3 Pleasant Ave Amendment App & Fast Track

From: John Shields <jshields1@maine.rr.com>
To: "Laurie Leader" <lr@portlandmaine.gov>
Cc: "Bob Gaudreau" <Bob@hardypond.com>
Date: Mon, 23 May 2016 12:31:01 -0400
Subject: 3 Pleasant Ave - Revision No 4

Drawing
LIFE SAFETY PLANS

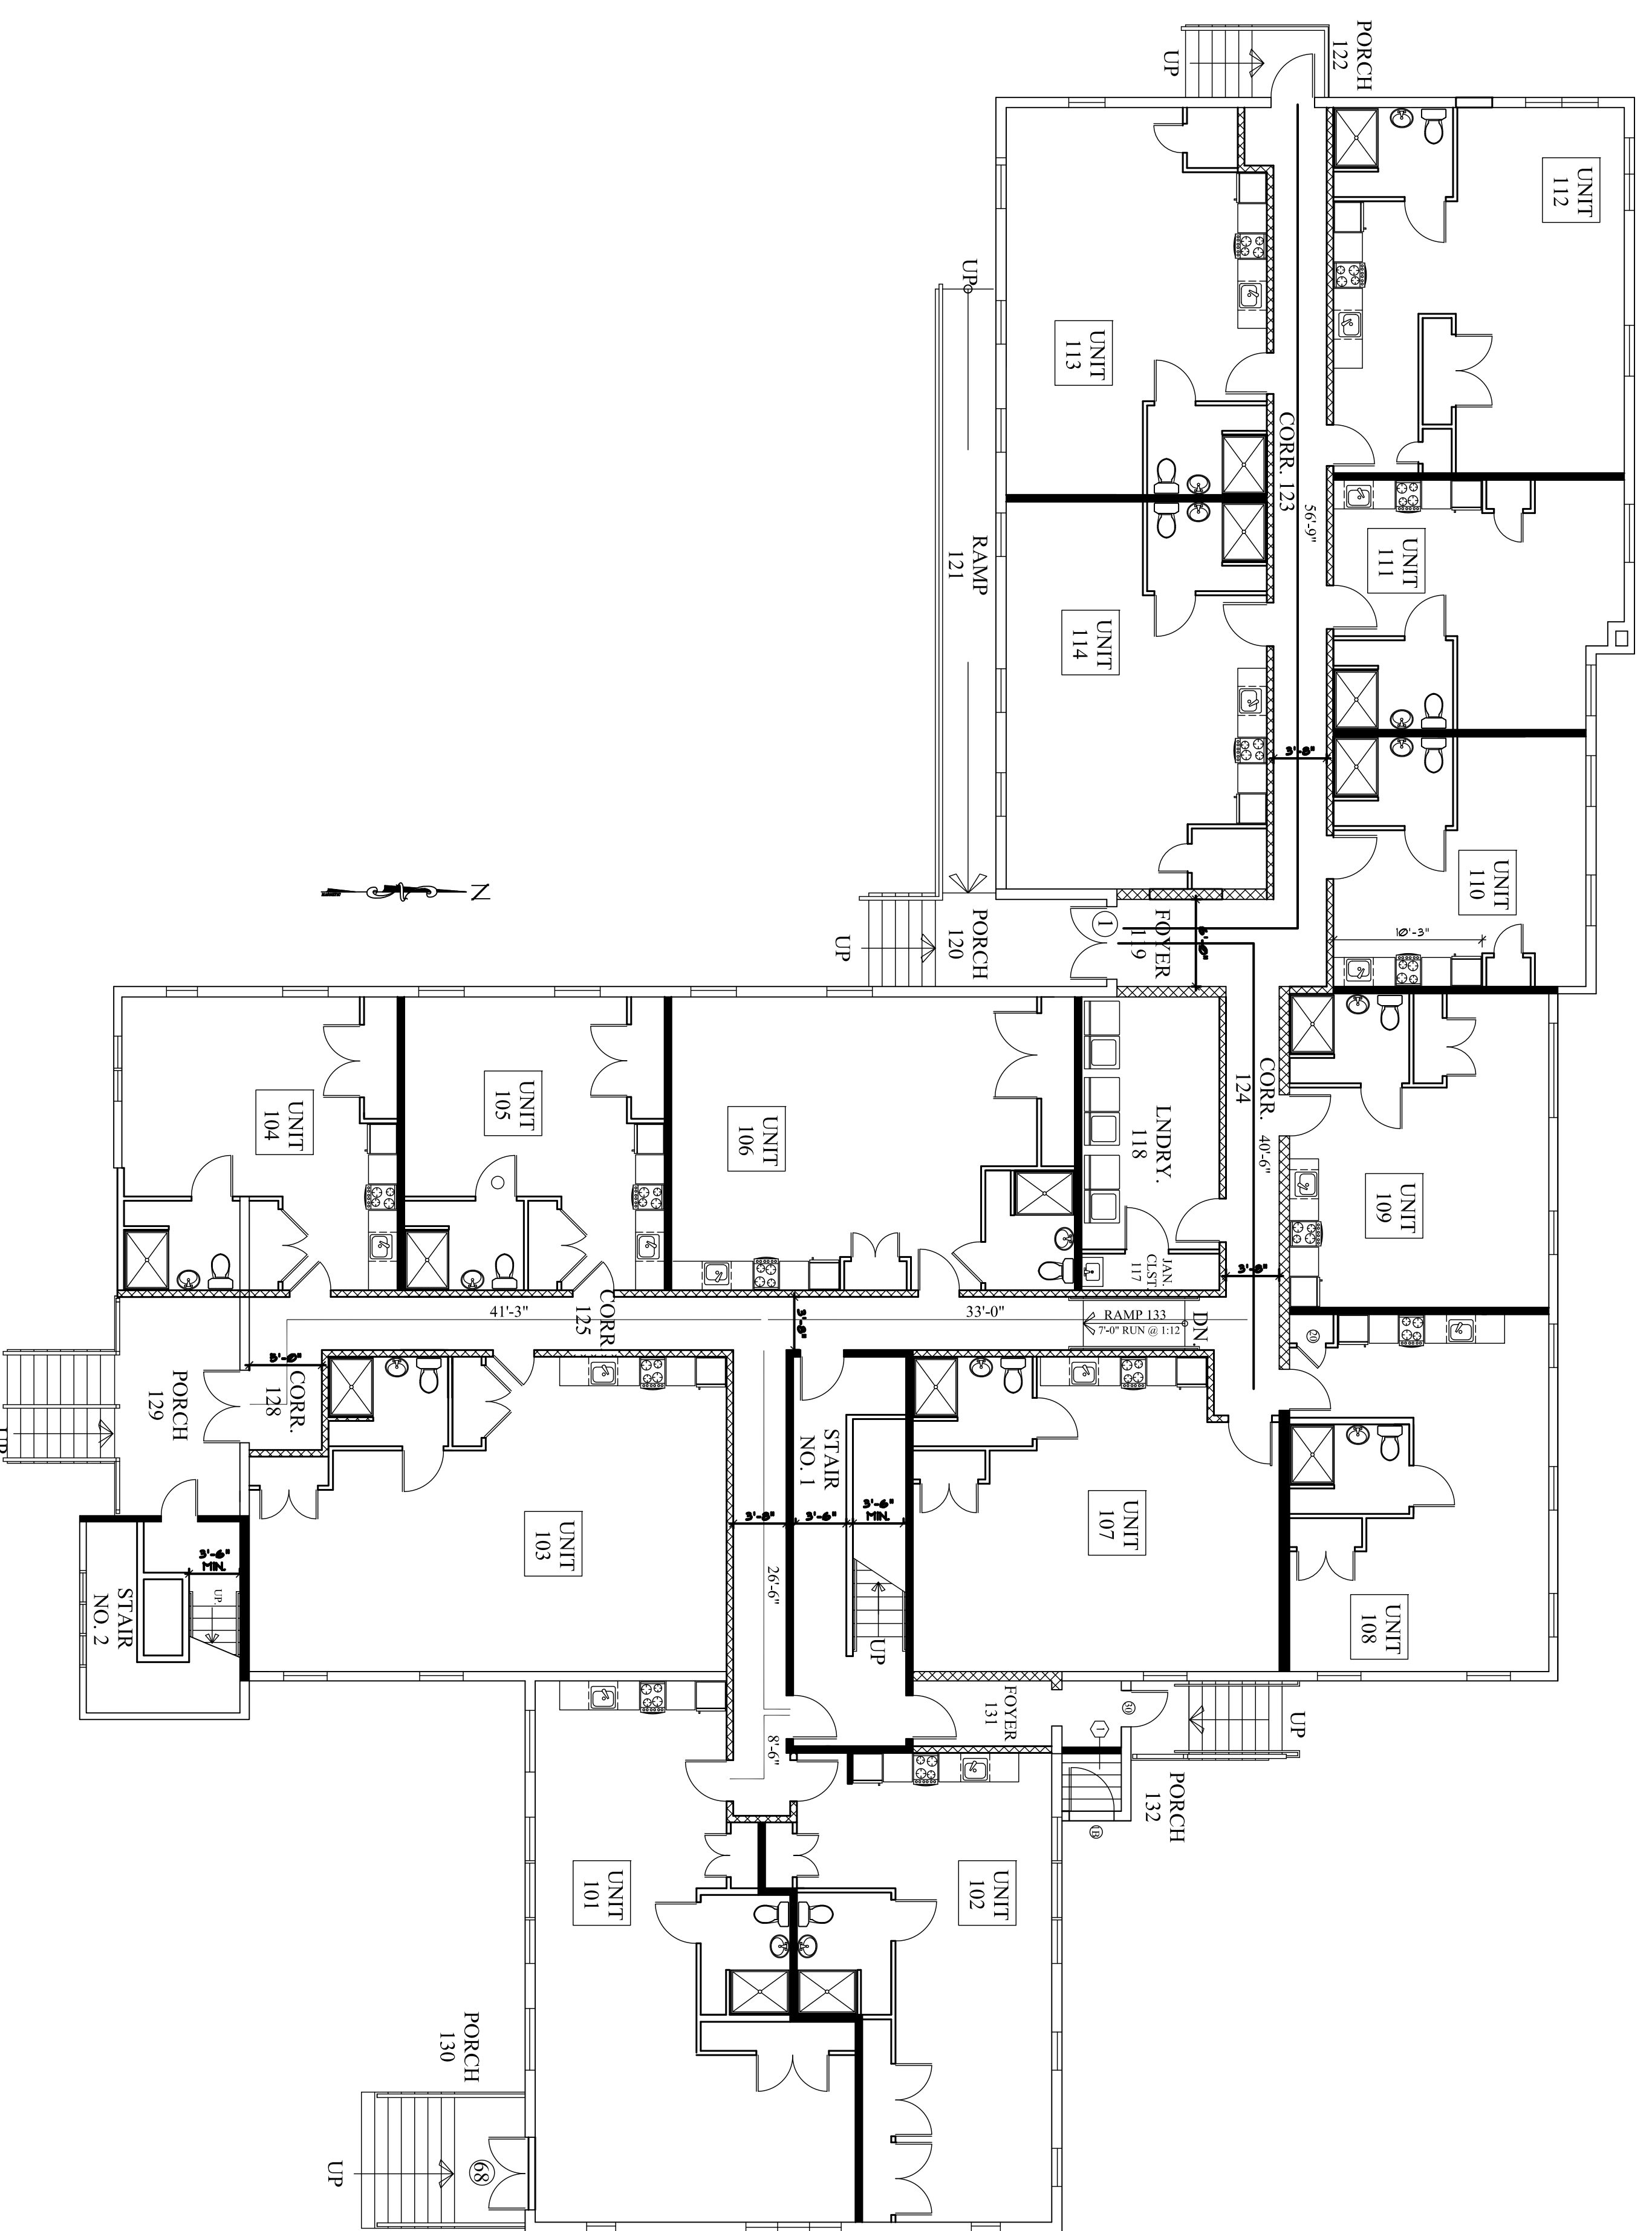
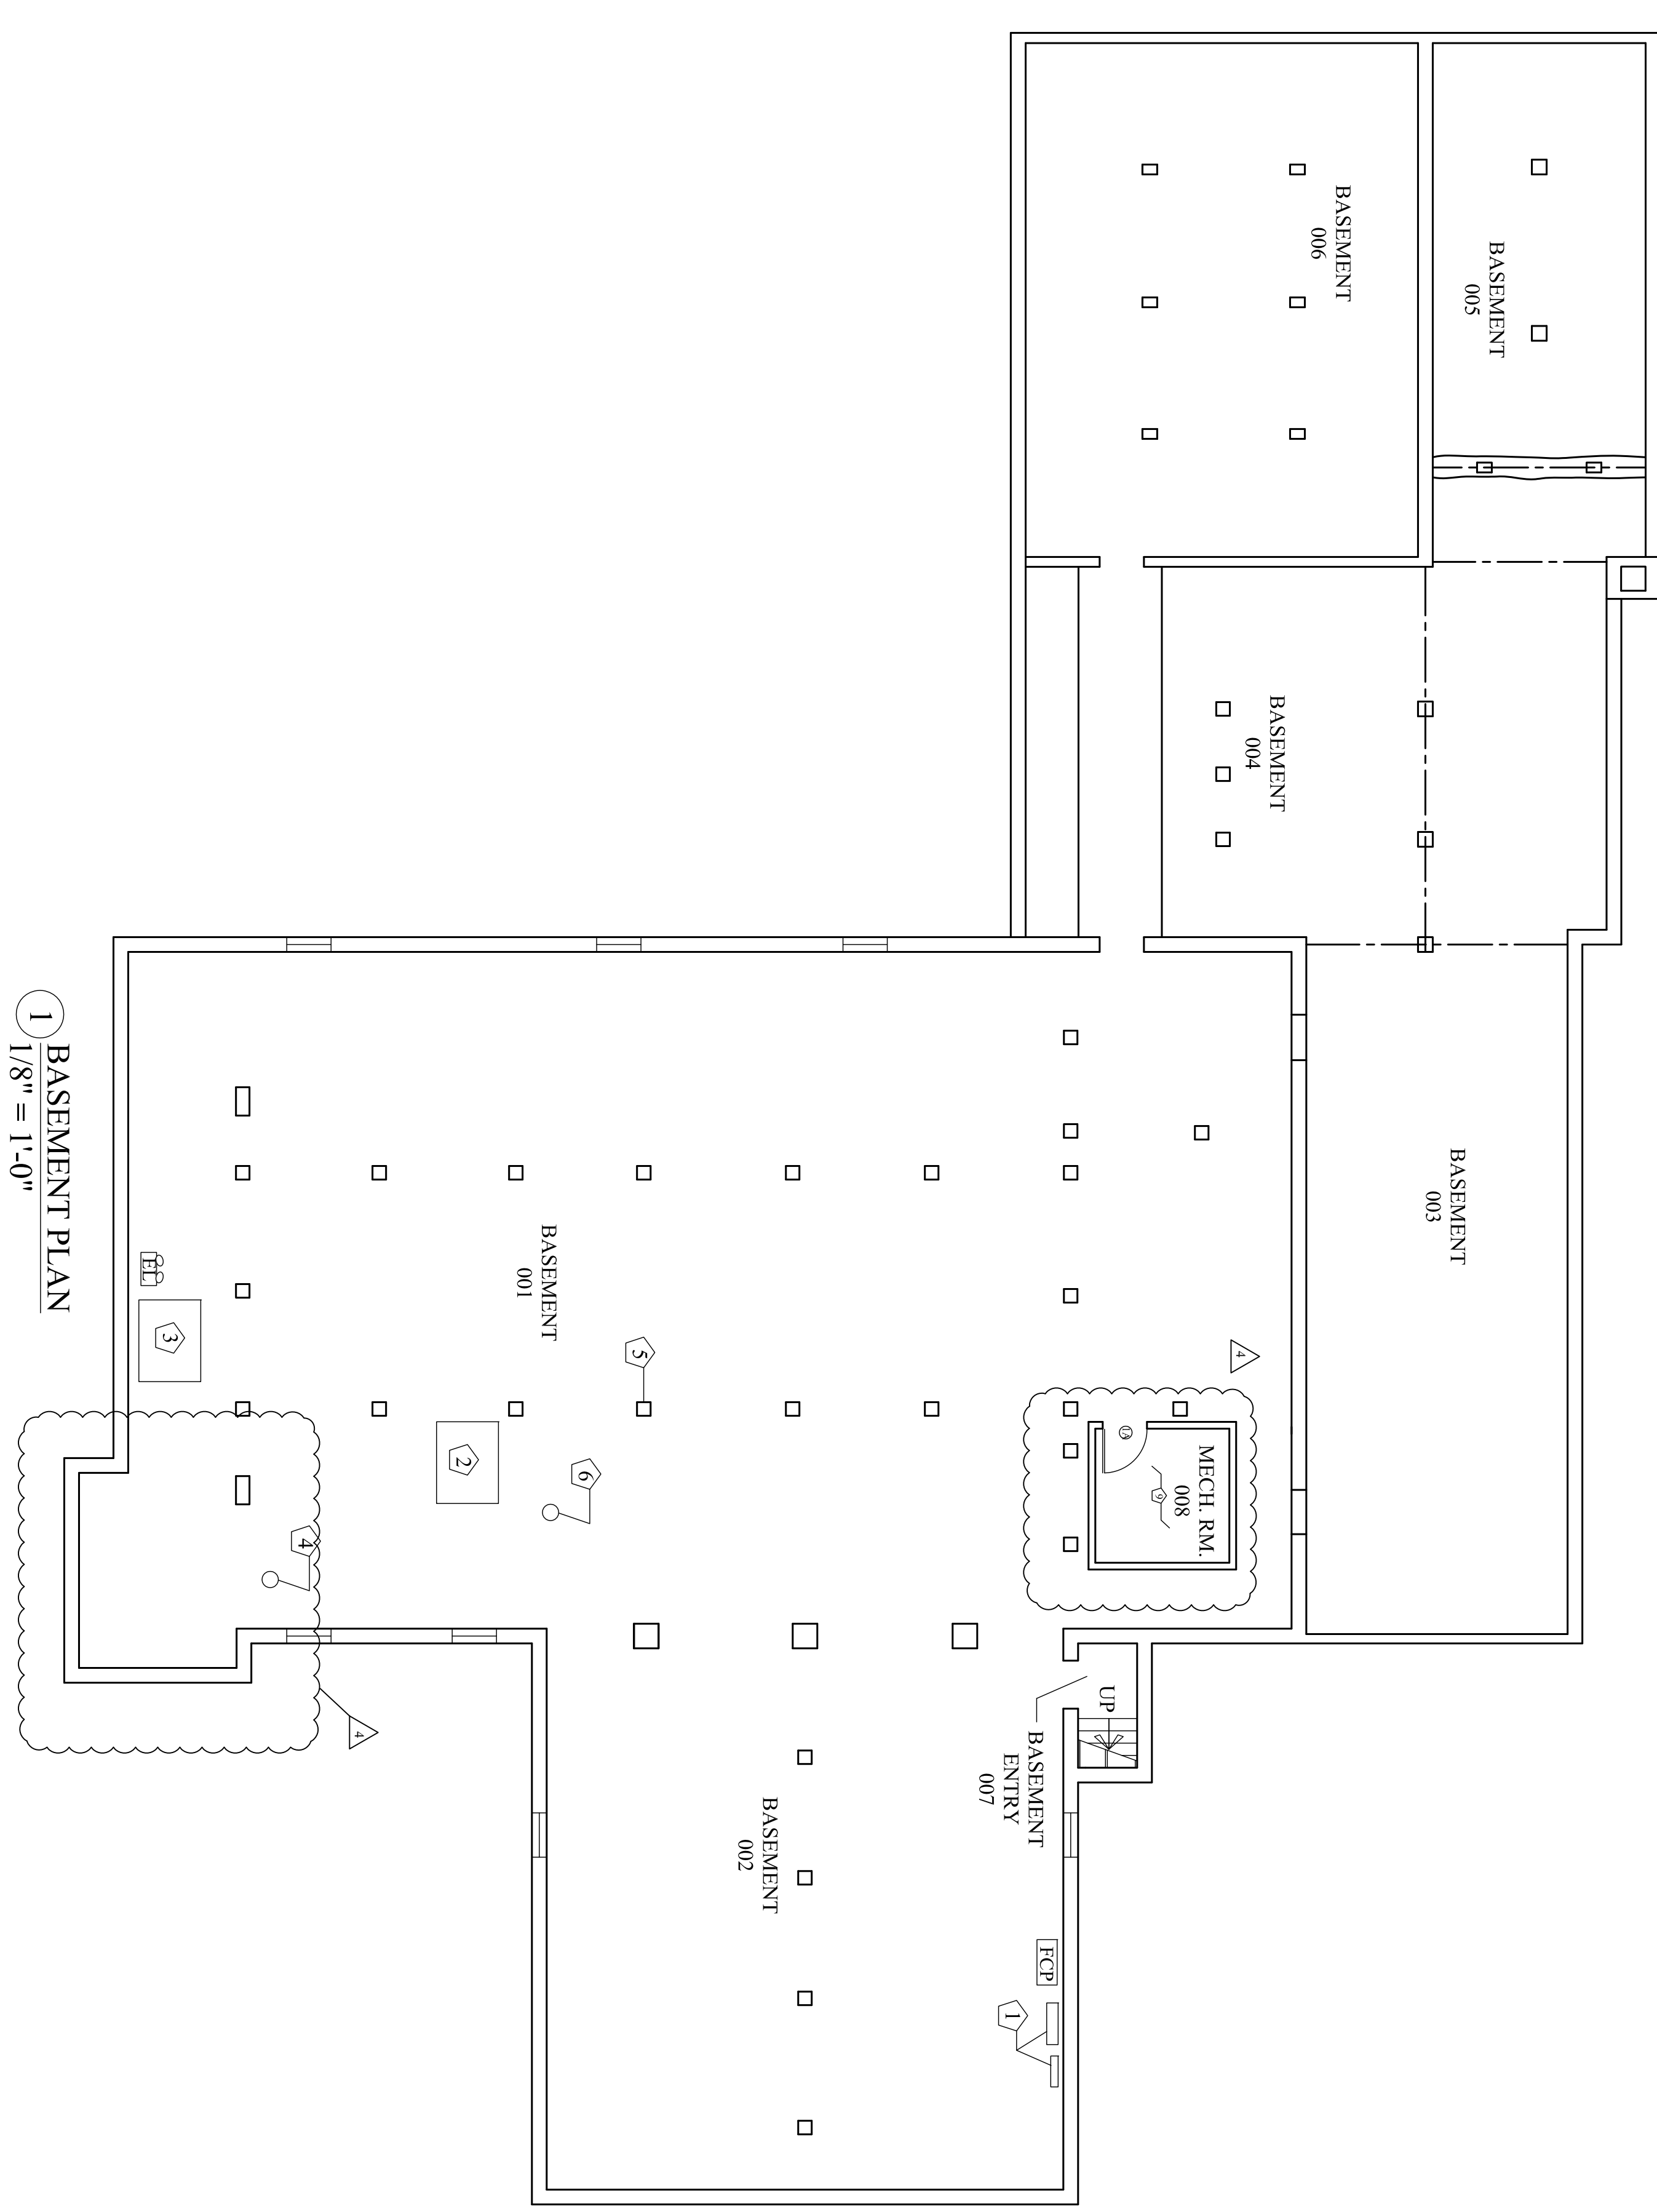
10. Drawing A-16 Fire Alarm & Smoke/CO Detector Plans: Basement Plan revised to show Mechanical Room 008 location.
11. Drawing A-17 Life Safety Plans: Basement Plan revised to show Mechanical Room 008 location.
